**KIRKLEES METROPOLITAN COUNCIL
INVESTMENT & REGENERATION SERVICE**

**DELEGATED DECISION TO DETERMINE APPLICATIONS FOR
CONSENT, AGREEMENT OR APPROVAL REQUIRED BY CONDITION**

Reference No:	2025/44/92836/E
Site Address:	The Priory, Whitechapel Road, Cleckheaton, BD19 6HR
Description:	Discharge of details reserved by conditions 5 (bat roosting), 6 (building contract), 7 (WSI), 8 (CEMP: Biodiversity), 9 (Phase II Intrusive Site Investigation Report), 13 (materials), 14 (security measures), 15 (boundary treatments), 16 (lighting), 18 (bin collection) on previous permission 2025/90655 for demolition of existing pub and erection of two storey building comprising 8 self-contained supported living flats with ancillary staff facilities, single storey summer house and other associated works
Recommending Officer:	Kerri Simpson

2025/92836- The Priory, Whitechapel Road, Cleckheaton, BD19 6HR

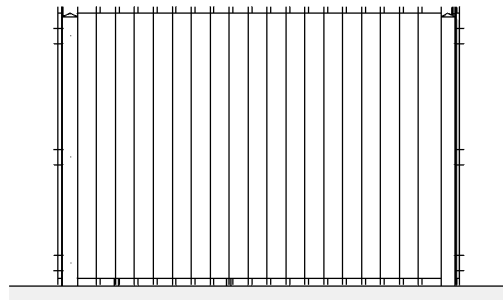
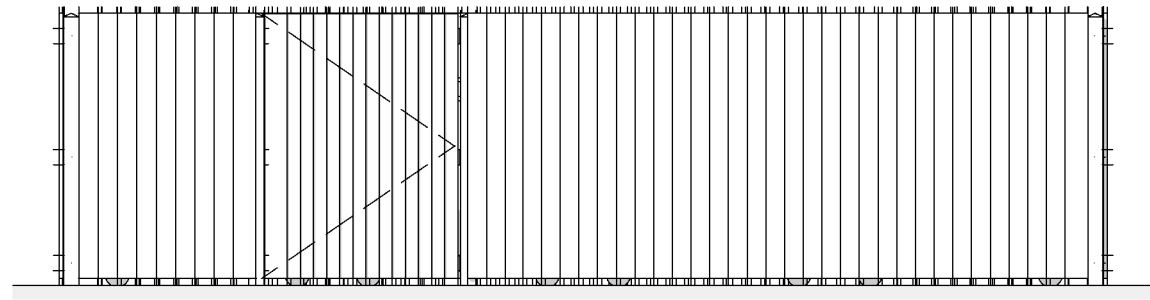
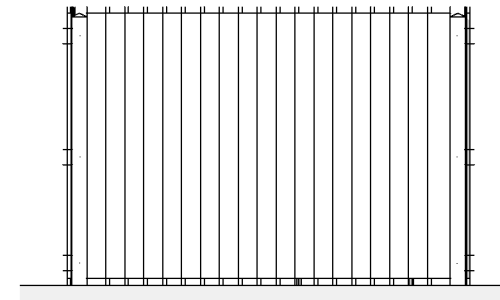
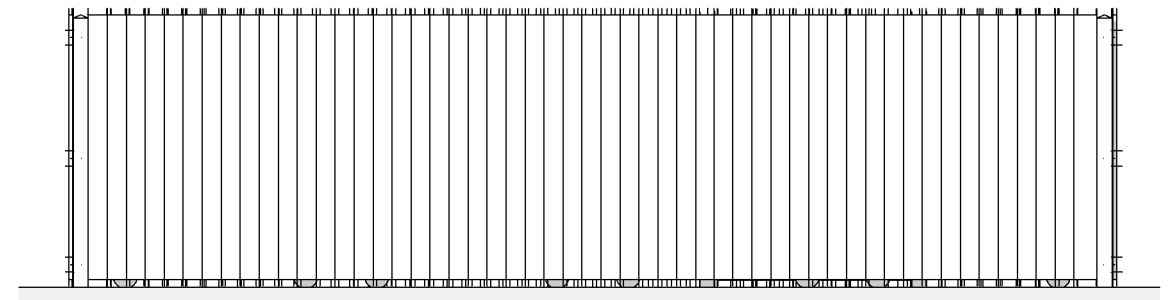
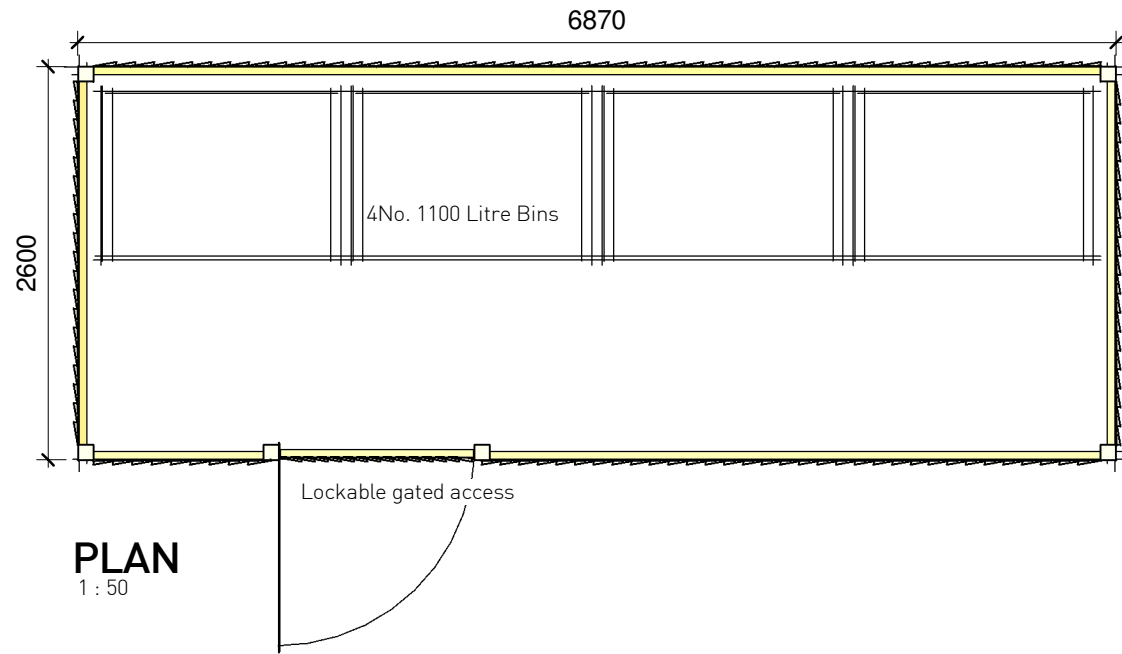
Comments were raised in respect of the size, layout and orientation of the bin store, including the requirement to accommodate 4 x 1100L bins and to ensure bins are positioned appropriately to facilitate ease of use and collection. Revised details have subsequently been submitted which demonstrate that the bin store would be of sufficient size and appropriately configured to accommodate the required bins with suitable access arrangements.

The bin storage arrangement would result in a minor alteration to the adjacent parking layout. However, the number of parking spaces is retained, and the layout continues to provide satisfactory access and manoeuvrability. The changes are not considered to materially depart from the approved scheme.
